AL/11/24/OUT – Response to WSCC Comments dated 24/04/26

DATE:	31 March 2026	CONFIDENTIALITY:	Public
SUBJECT:	AL/11/24/OUT – Response to WSCC Comments dated 24/03/26		
PROJECT:	Land at Westergate	AUTHOR:	Philip Moss
CHECKED:	Chris Williams	APPROVED:	Andrew Blacker

This Technical Note has been prepared by WSP to provide a response to the Highways comments provided by West Sussex County Council (WSCC) on the 24 March 2026 in their role as the Local Highway Authority. This document provides a summary of the comments raised by WSCC with the WSP response provided below.

DRAWING No:	LAW-WSP-ZZ-ZZ-C-DR-00006	REV:	P03
© WSP UK Ltd

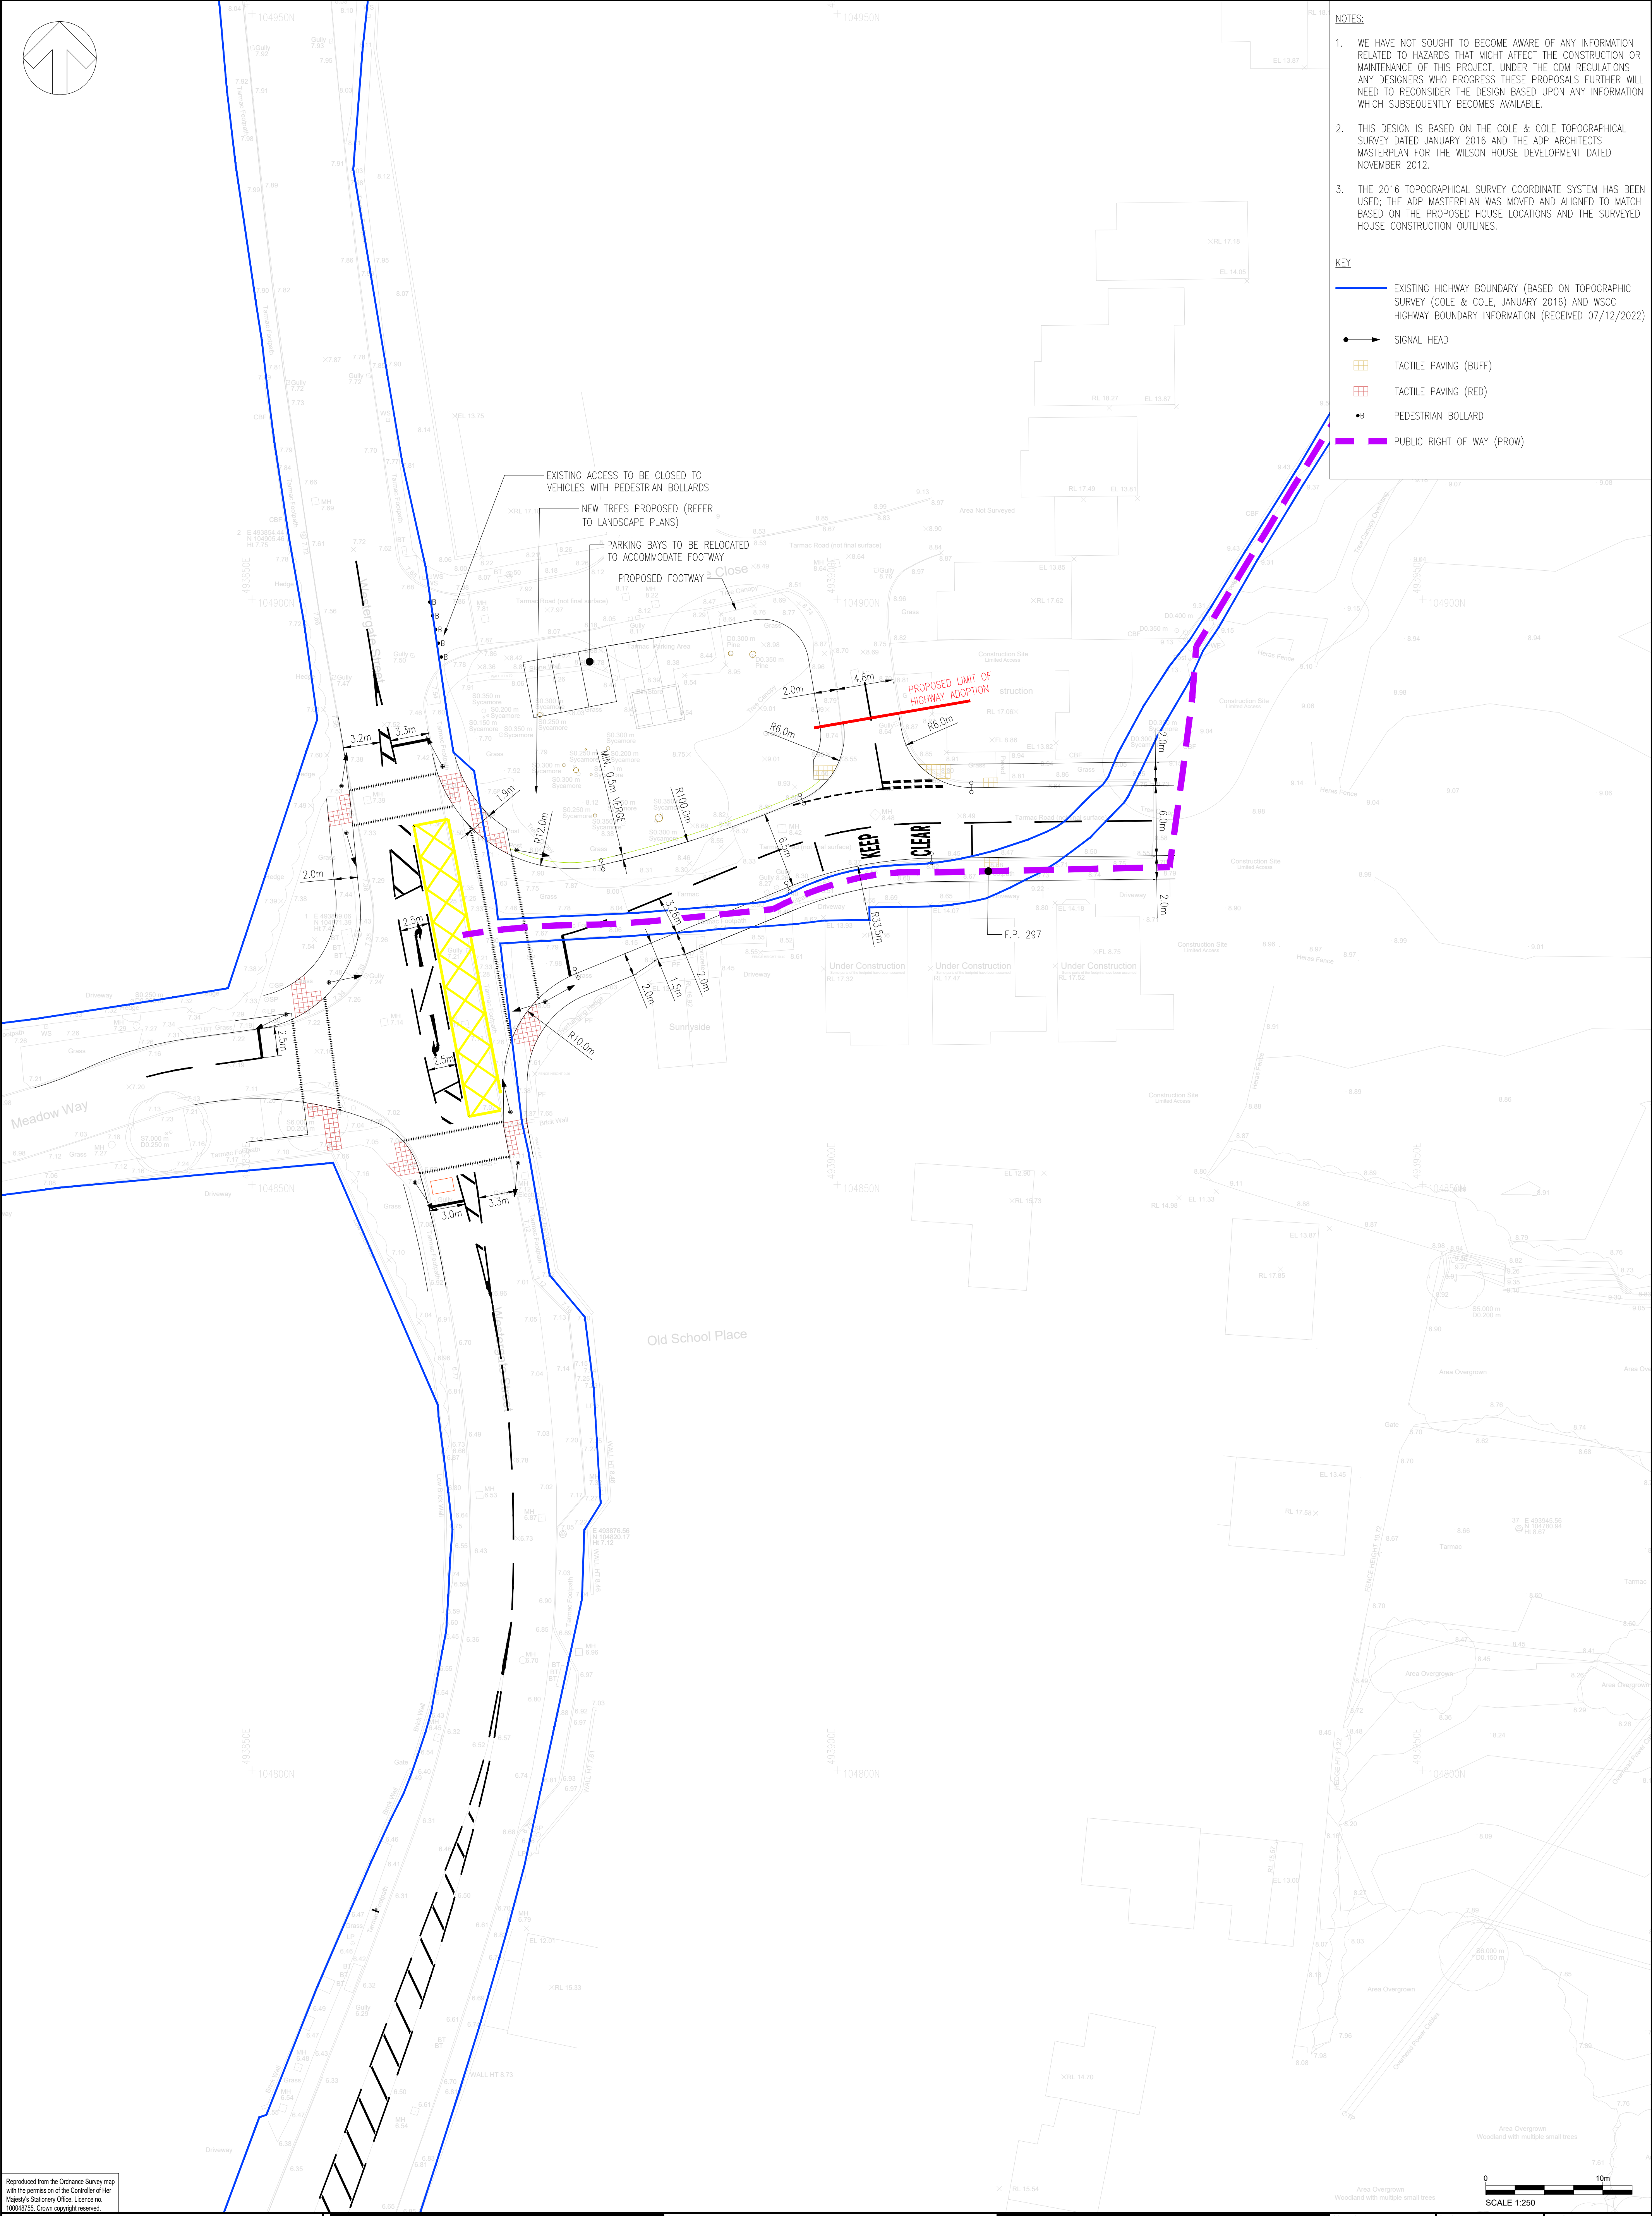
Closure of Pine Close – Engineering detail of closure required. Please can a solution for this be considered in more detail.

Drawings LAW-WSP-ZZ-ZZ-C-DR-00006 (Site Access General Arrangement) and LAW-WSP-ZZ-ZZ-C-DR-00007 (East West Link Road General Arrangement) have been updated to provide revised proposals for the closure of Pine Close as shown in Figure 4. This allows for a continuous footway along Westergate Street.

SCALE FOR PLANNING PURPOSES ONLY

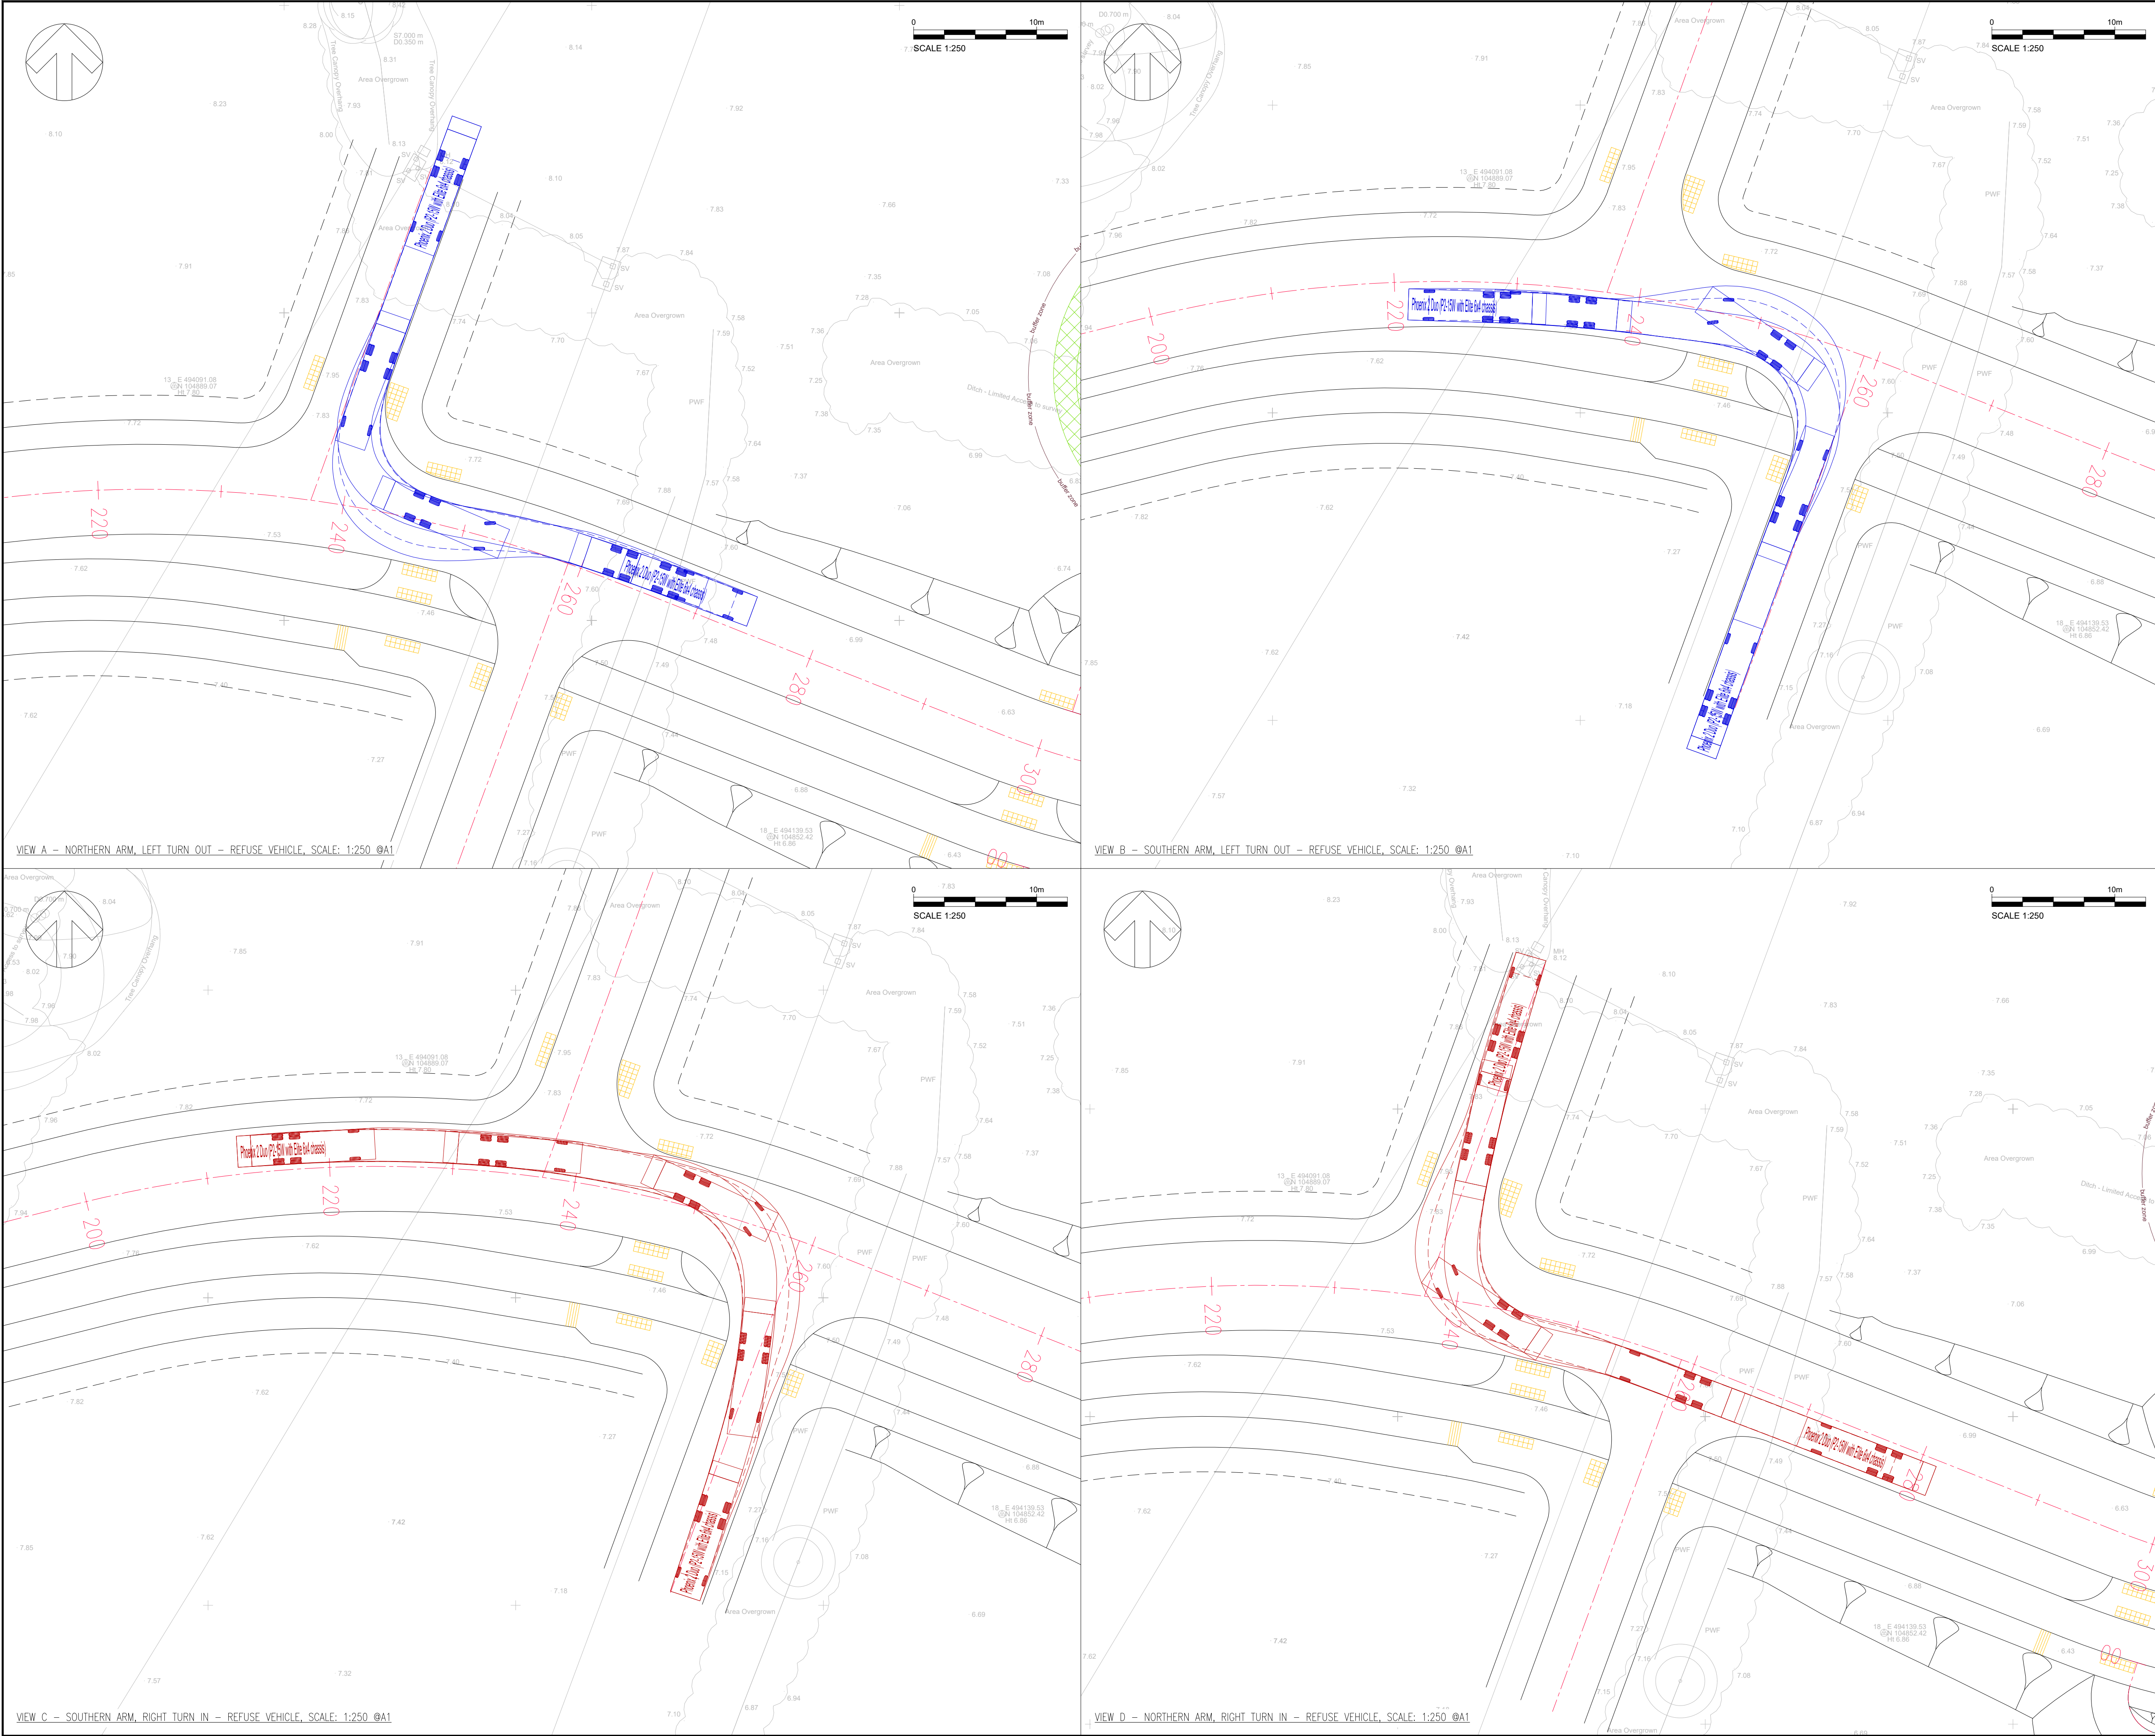
Foot and cycle infrastructure on bridge forming part of E-W link – Please add a note on relevant drawings to state that details of the E-W link east of the bridge are to be confirmed as part of reserved matters applications for the Church Commissioner's land. Also, please demonstrate that the proposed pedestrian / cycle infrastructure meet the requirements of LTN 1/20 with regard to dimensions, including kerb and verge spacings to/from the carriageway and 'scare' distance from parapet and 'live' traffic etc.

As requested an additional note has been added to WSP Drawings LAW-WSP-ZZ-ZZ-C-DR-00007 included in Appendix A which states that "the East West Link Road alignment, including associated pedestrian and cycle infrastructure provision, is to be confirmed as part of Reserved Matters applications related to BN11/22/OUT".

It can also be confirmed that the proposed pedestrian and cycle infrastructure shown on WSP drawing LAW-WSP-ZZ-ZZ-C-DR-00007 are aligned with LTN1/20 design standards through provision of the following:

- A 3m wide fully segregated bidirectional cycle route, which is in accordance with the desirable minimum width for cycle flows of up to 300 cyclists per hour as shown in Table 5-2 of LTN1/20.
- A 1.5m segregated verge along the East-West Link Road, reducing to 0.5m over the bridge. This in accordance with the desirable minimum horizontal separation between the carriageway and cycle track for a 30mph speed limit, as shown in Table 6-1 of LTN1/20.
- Provision of low / splayed kerbs between the cycle track, footway and buffer zone meaning that no additional width is required for the cycle track.
- Priority is maintained for cyclists at the southern side-road access of the masterplan, with vehicles required to give-way to cyclists using the bidirectional cycle track.
